# CITY OF ALBUQUERQUE

**Re: Broadway McKnight Apartments**  
**300 McKnight Ave. NE**  
**Request for Certificate of Occupancy**  
**Transportation Development Final Inspection**  
Engineer's Stamp dated 12-07-20 (H14-D112)  
Certification dated 05-01-23

Based upon the information provided in your submittal received 05-03-23, Transportation Development cannot approve the release of Certificate of Occupancy for the above referenced project.

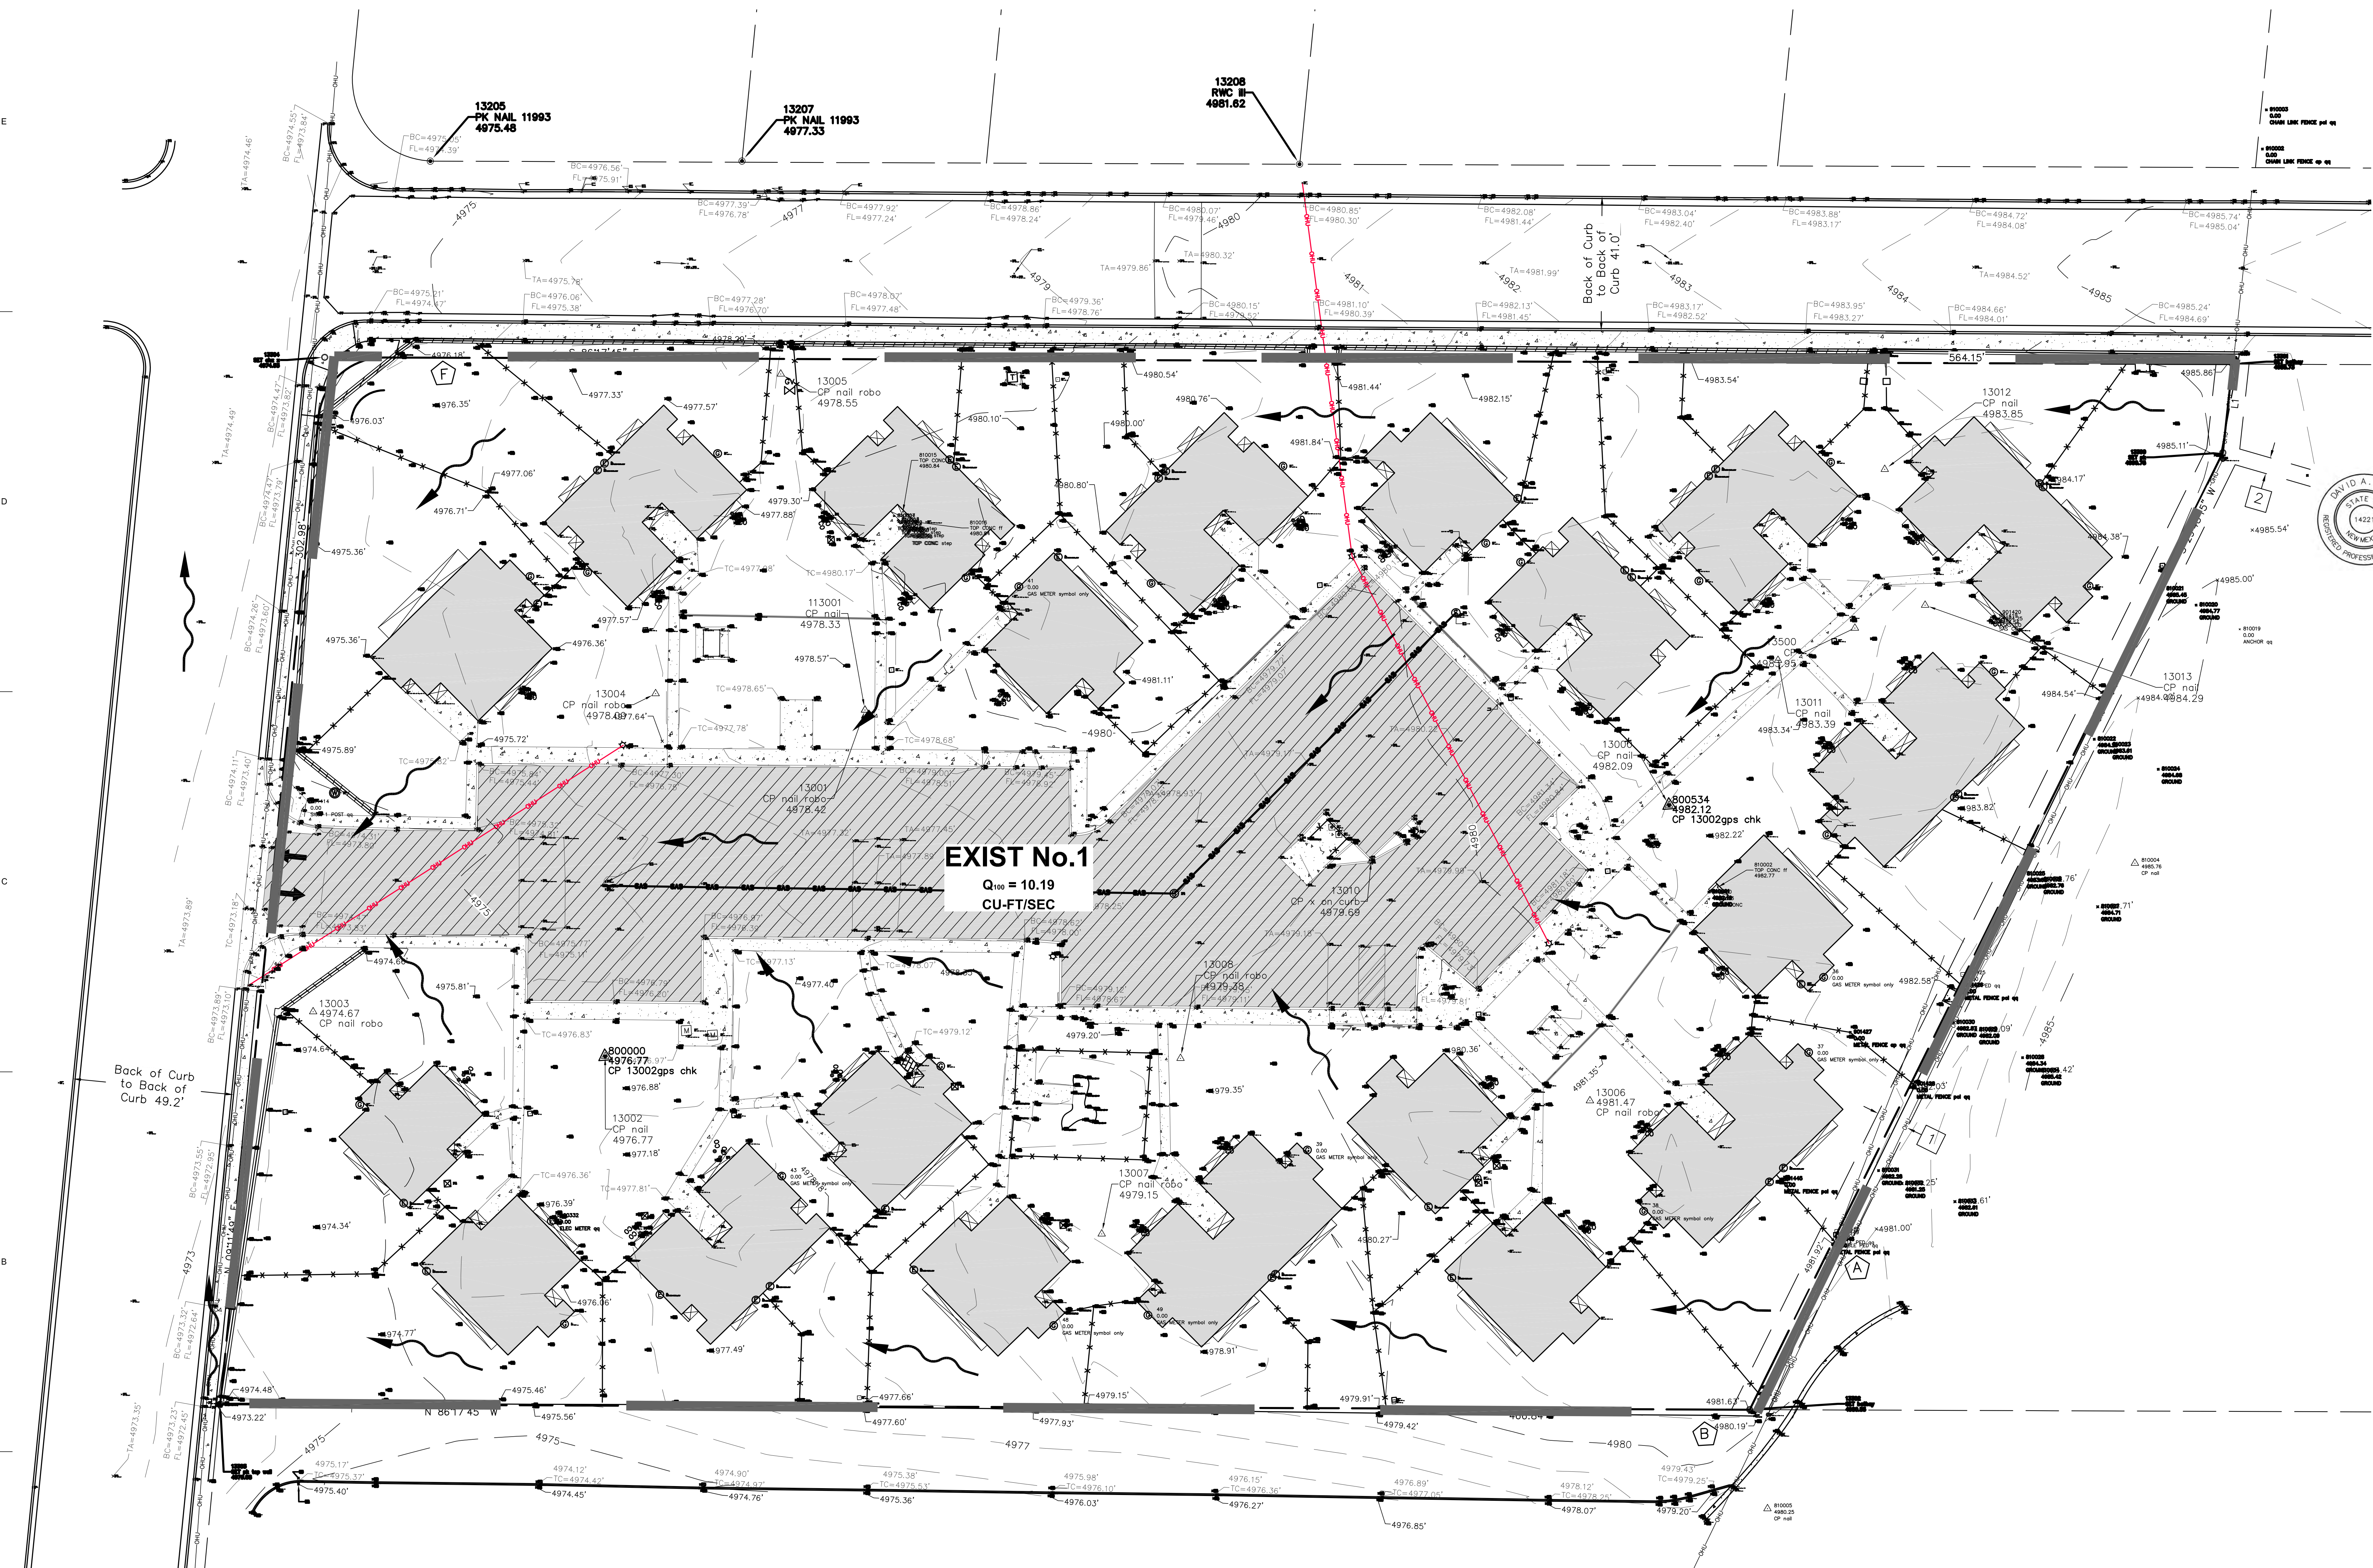
- Per approved site plan keynote 8: parking stall asphalt pavement, but per site visit the parking stall area was fine crushed gravel. Please address this concern.
- Please provide "NO PARKING" pavement marking on the ADA aisle at the west side of the building J. The ADA access aisles shall have the words **"NO PARKING"** in capital letters, each of which shall be at least one foot high and at least two inches wide, placed at the rear of the parking space so as to be close to where an adjacent vehicle's rear tire would be placed. (66-1-4.1.B NMSA 1978)
- Per site visit, there were Motorcycle parking space at the east side of building F. Please red mark the site plan to reflect the change.

1. The approved and stamped TCL, Administrative Amendment, or Site Plan for Building Permit with changes drawn in red.
2. Transportation Certification letter on either the plan or applicant's letterhead.
3. A Drainage Transportation Information Sheet (DTIS)
4. Send an electronic copy of your submittal to [PLNDRS@cabq.gov](mailto:PLNDRS@cabq.gov).
5. The \$75 re-submittal fee.
